**Application for Planning Permission for Works or Extension to a Dwelling**

**Development:** Alterations to existing dwelling including; Part two storey part single storey rear extension, balcony, removal of cladding and rendering walls. Removal of existing pitched roof and repair replacement of flat roofs. New front porch extension.

**Location:** 18 Willowhayne Avenue East Preston BN16 1PE

Plans (1:50)

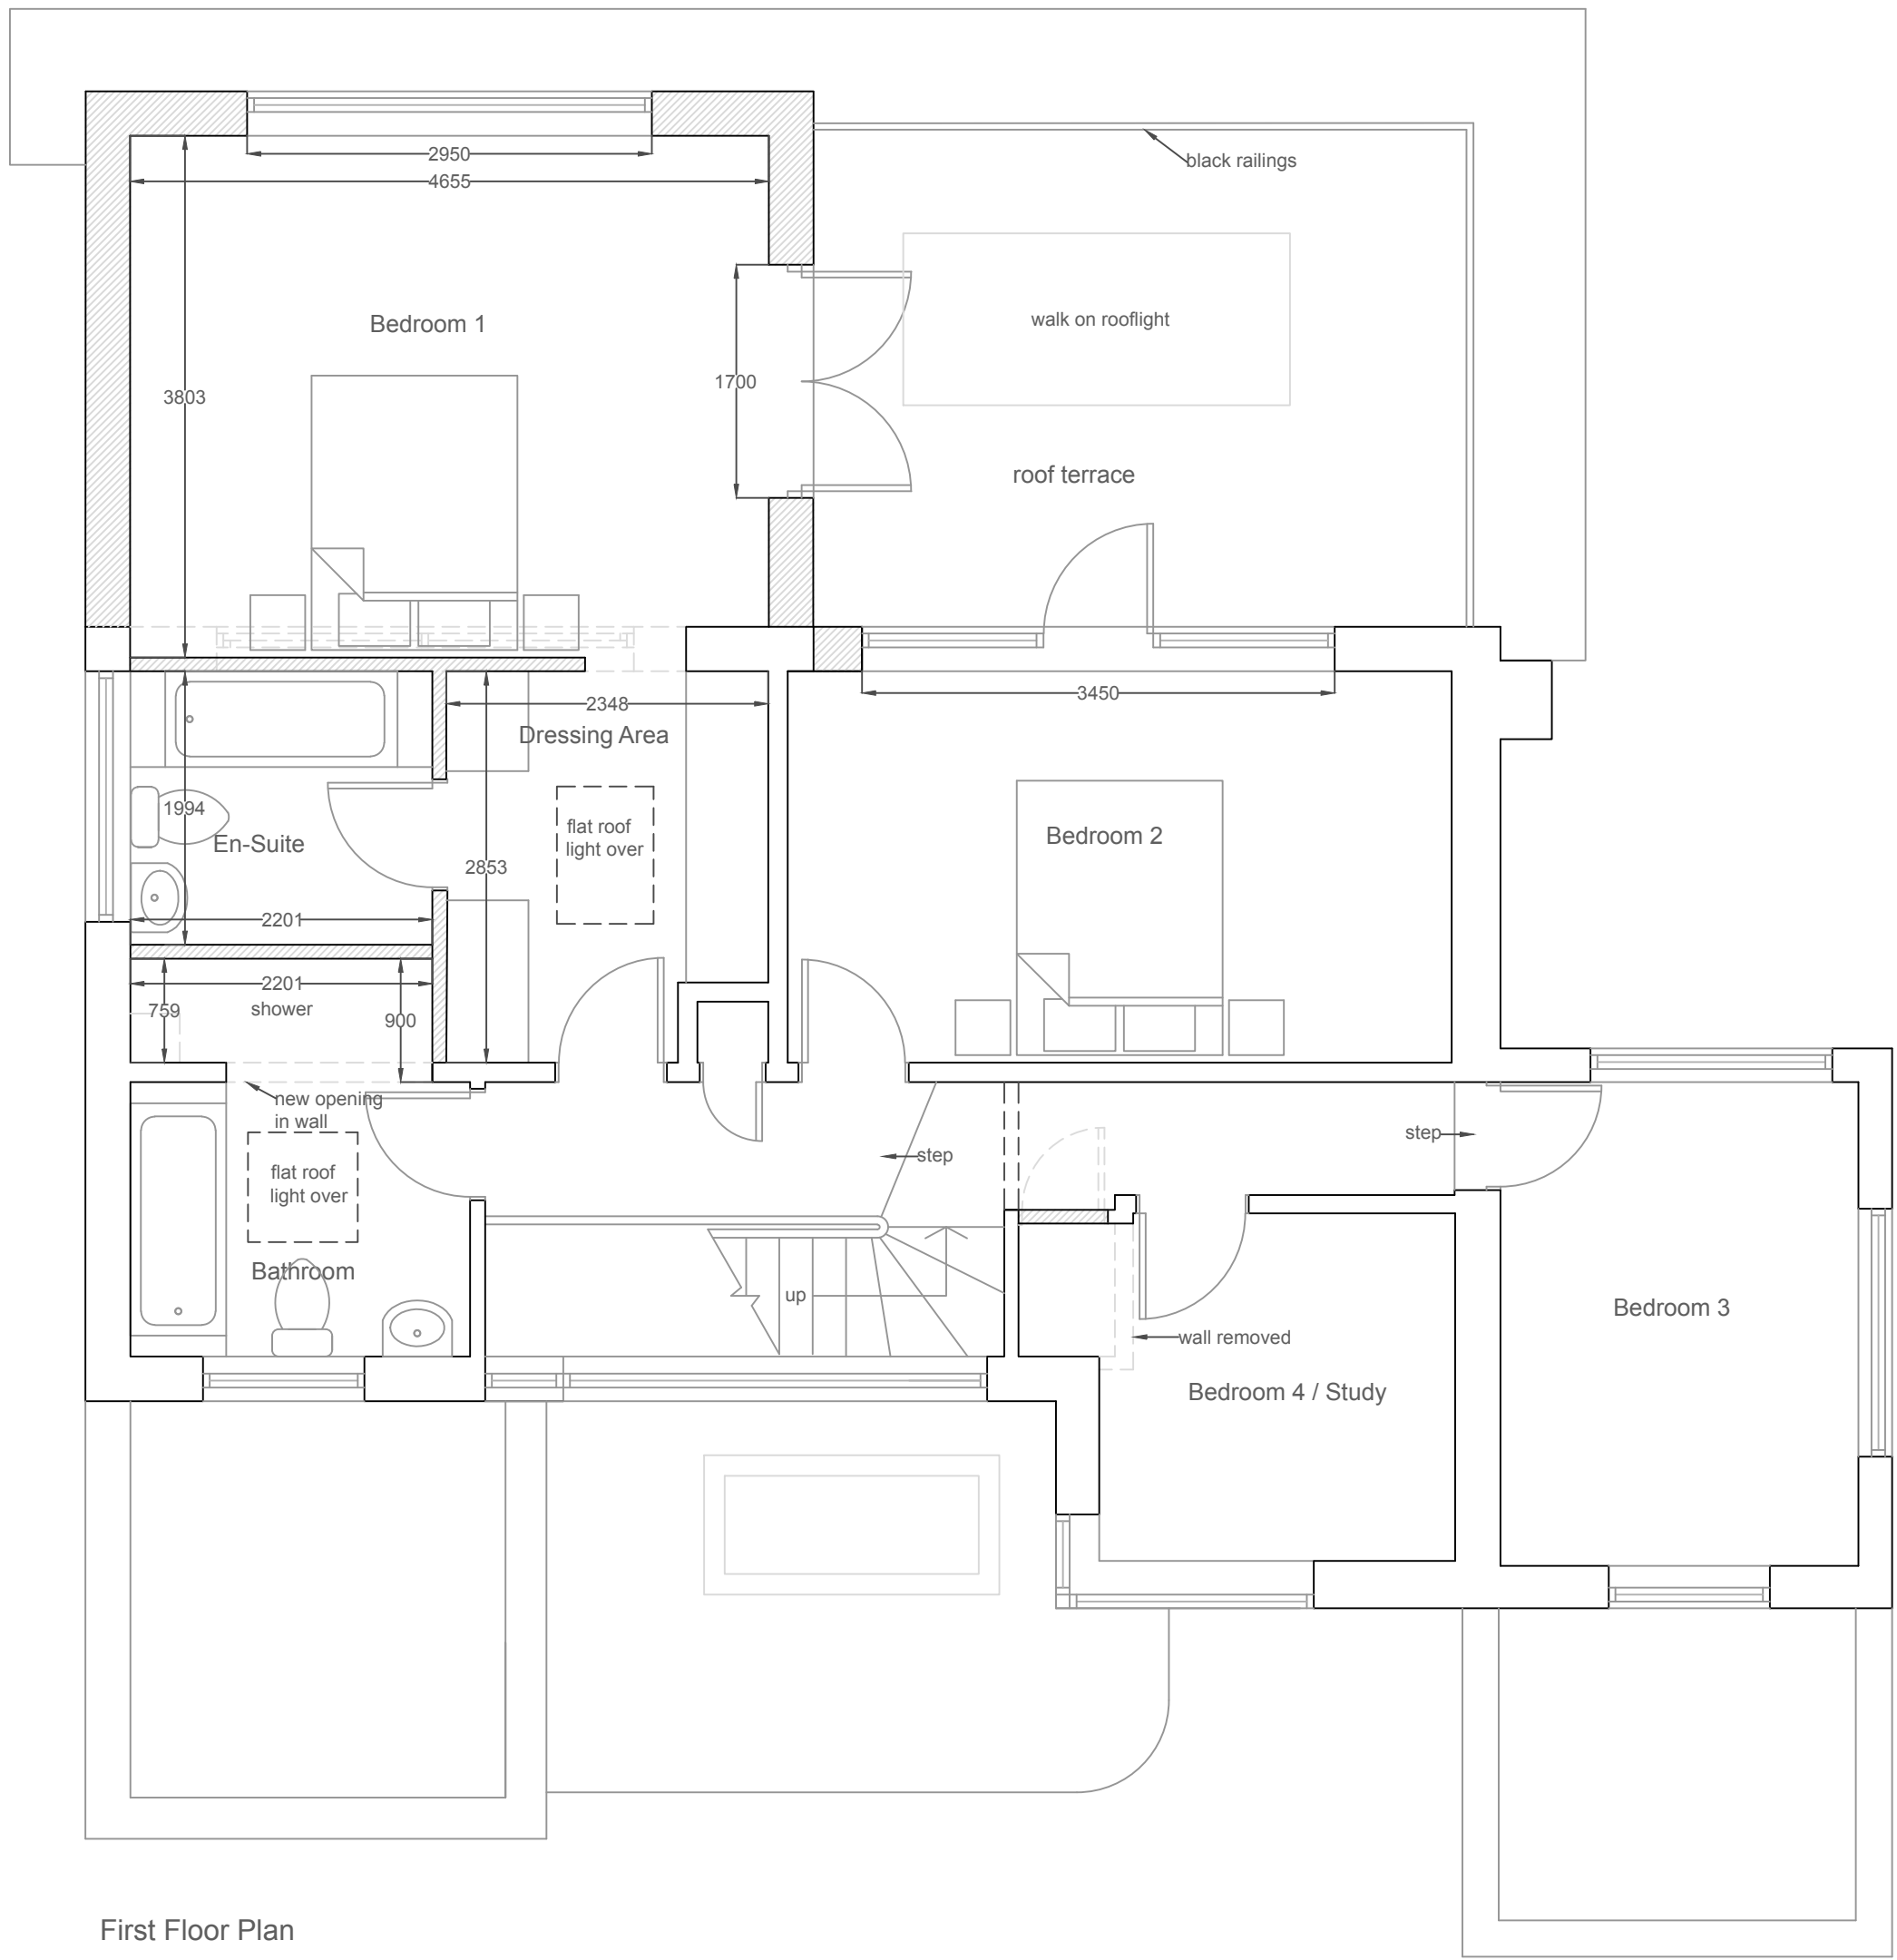
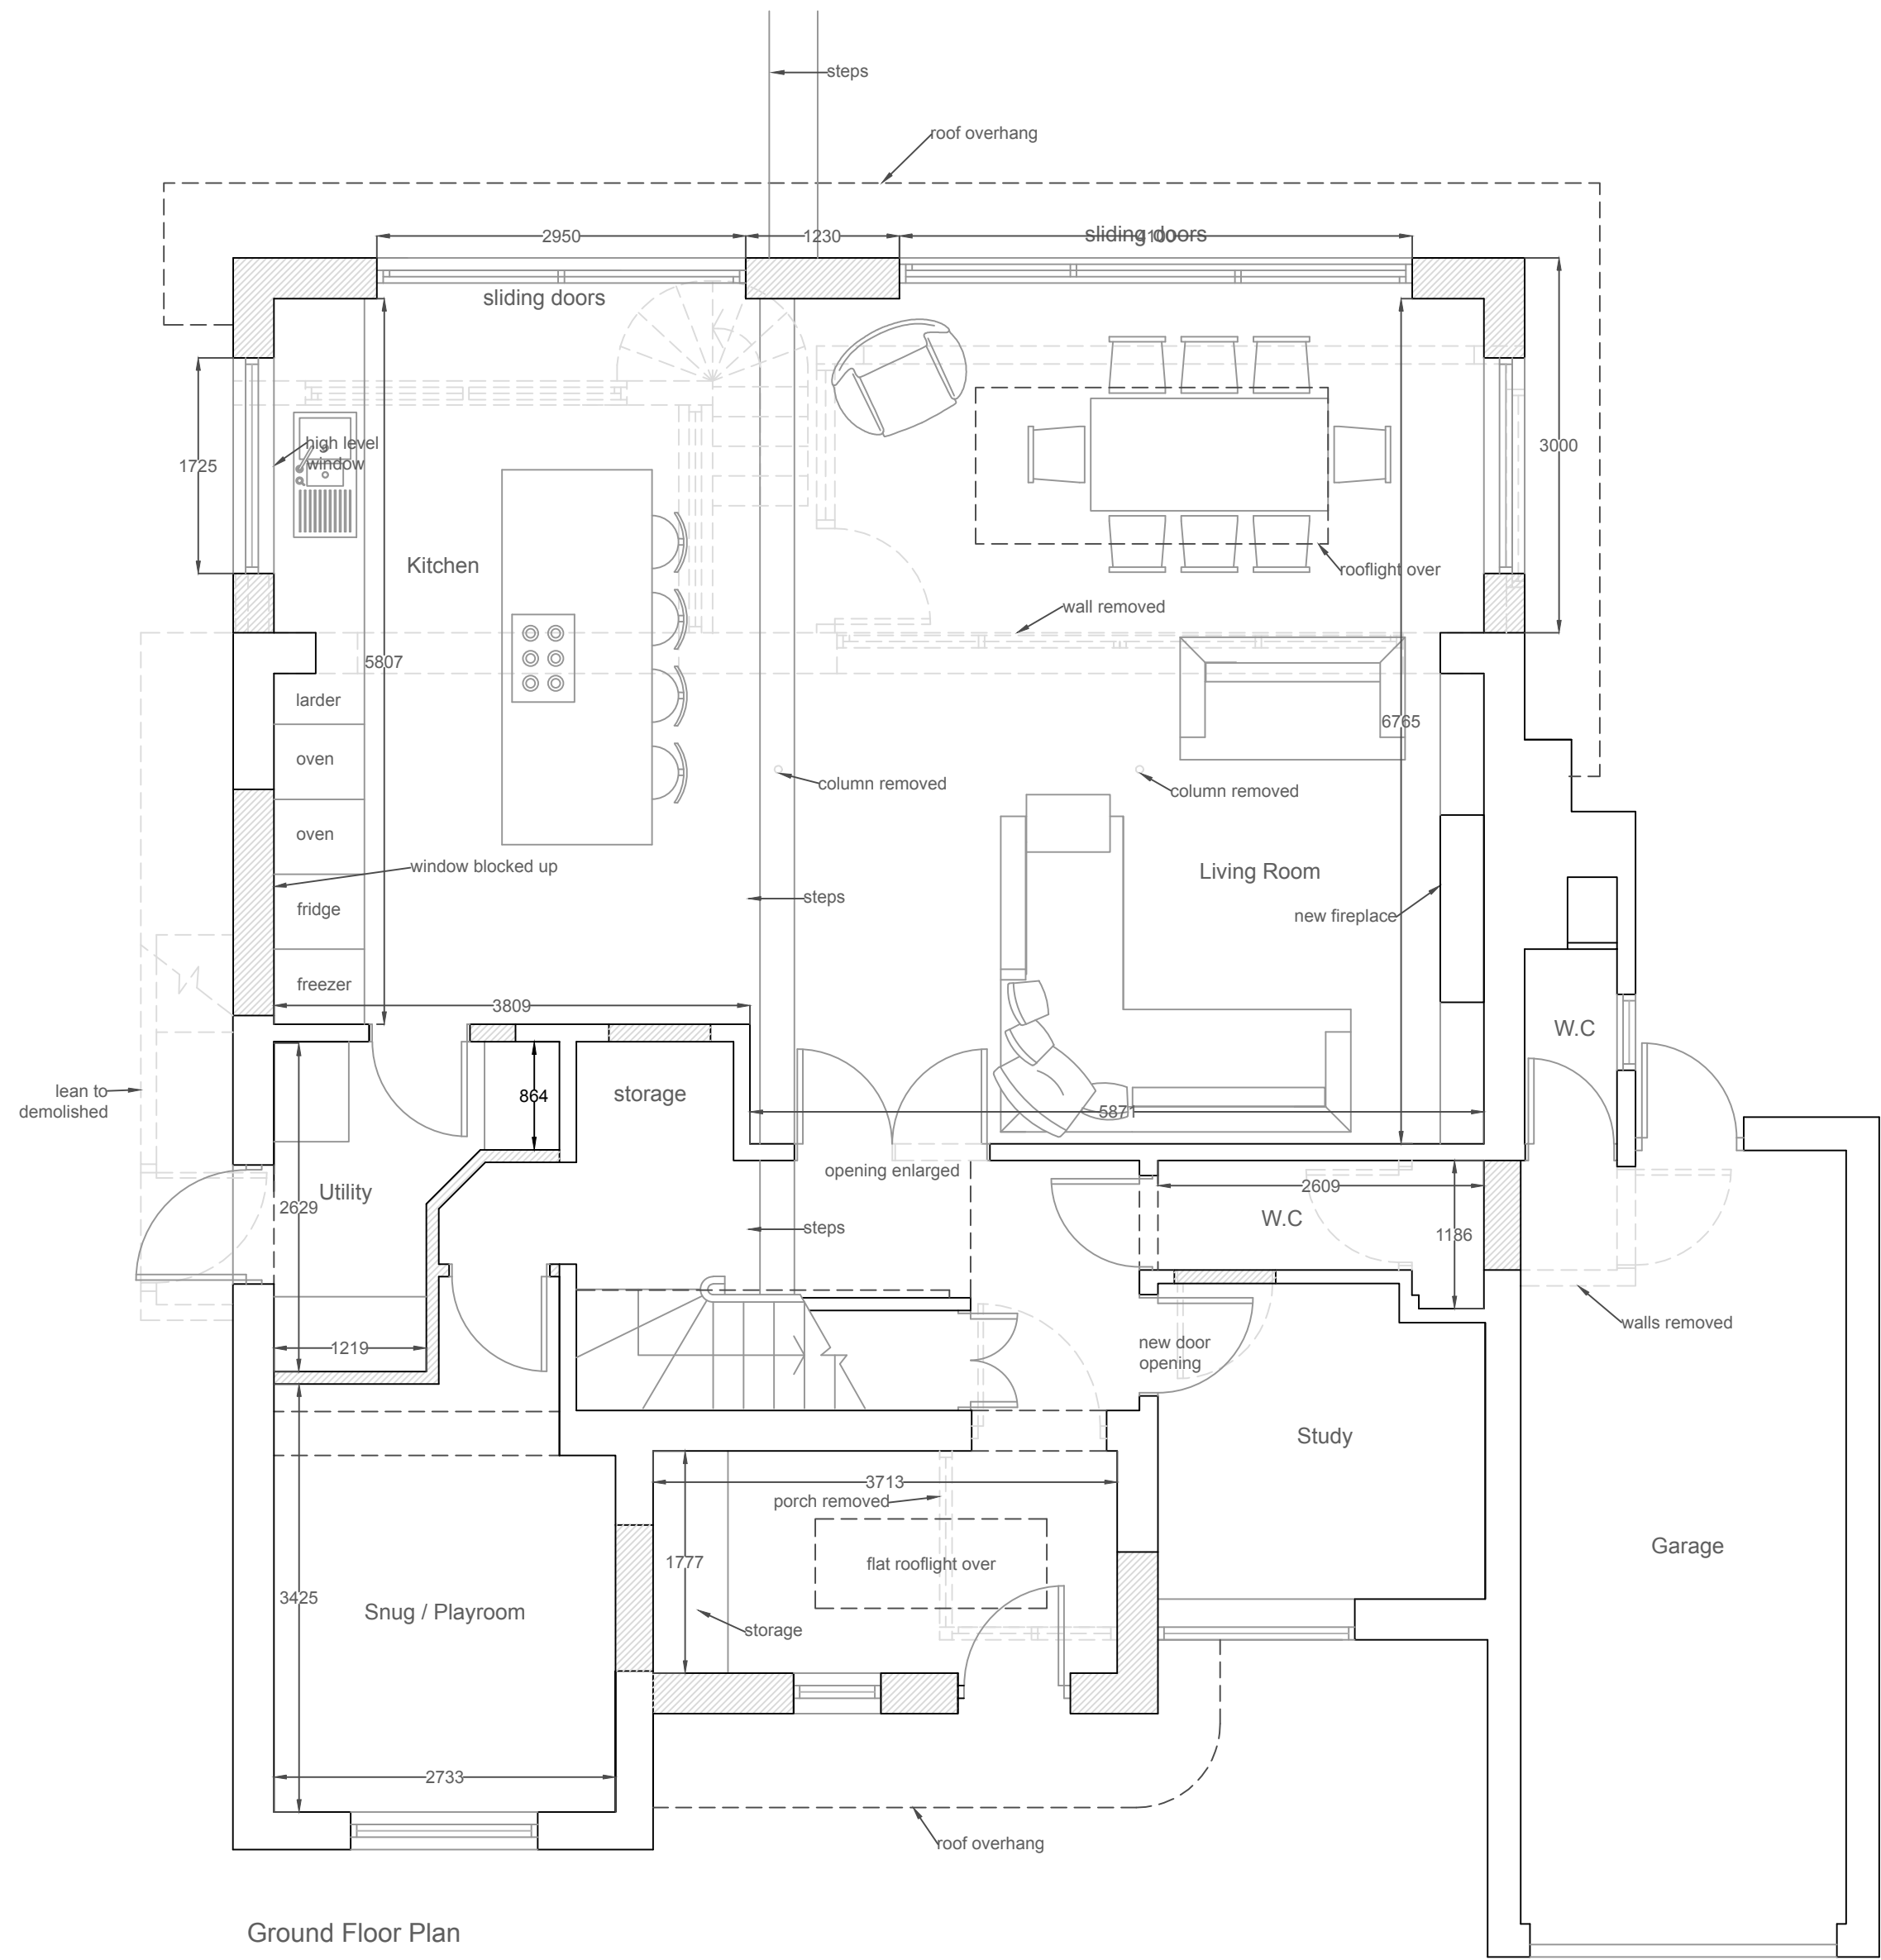
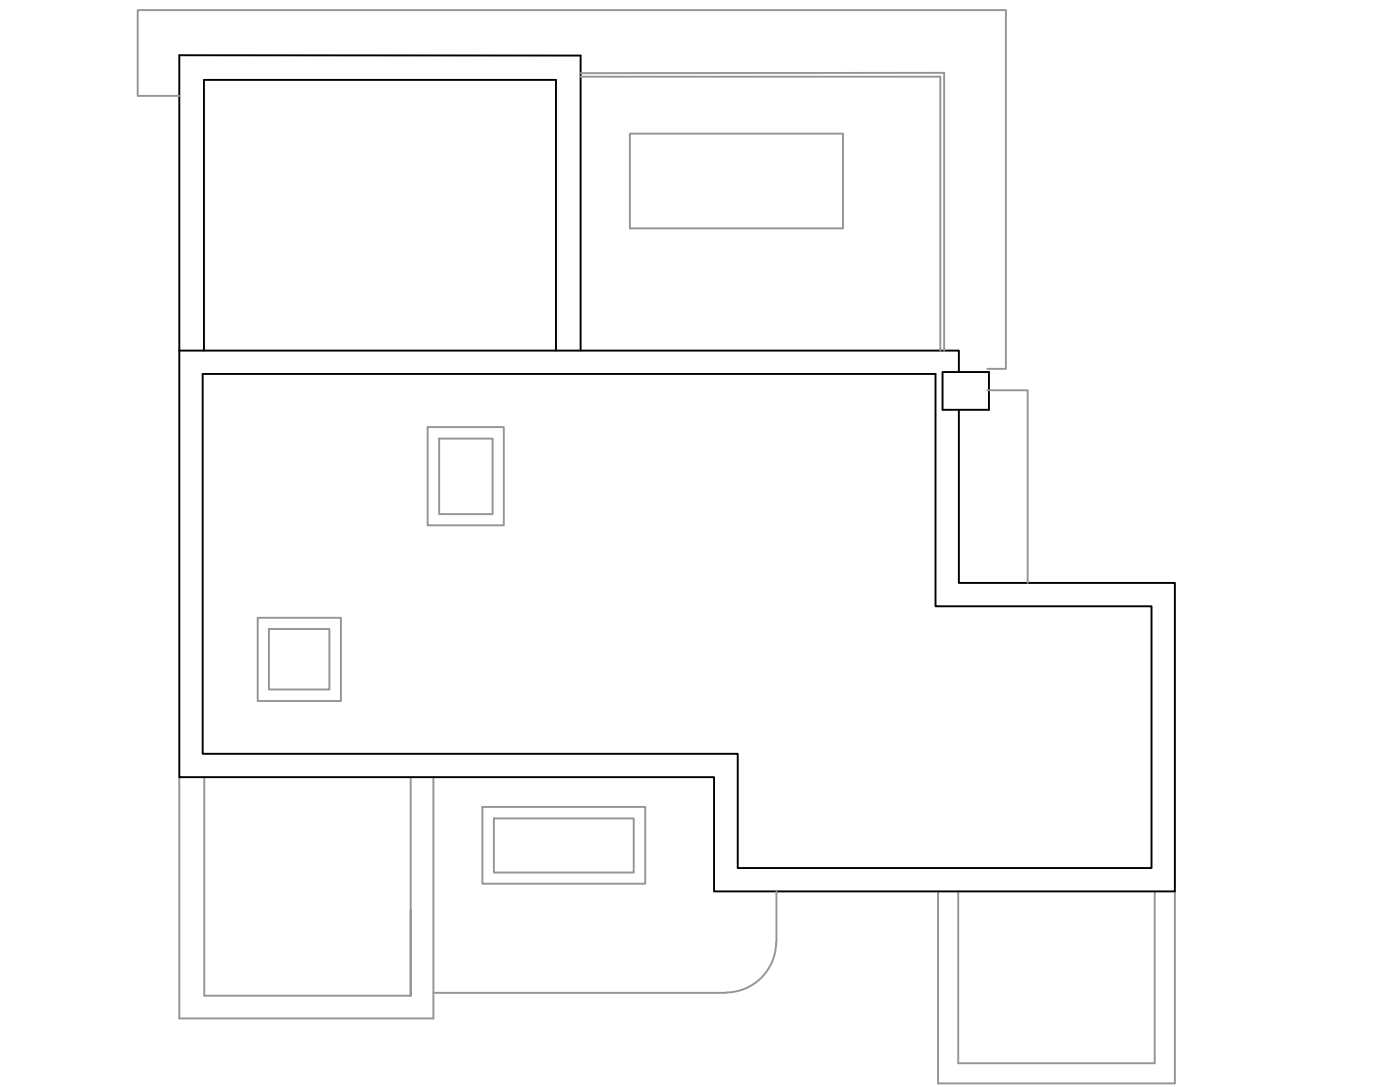
The rear building line is inconsistent with the floor plan. Please amend.  
**Plans**

You have stated the pitched roofs are being removed, please confirm what the roofs are going to be e.g. flat, gable end, etc.
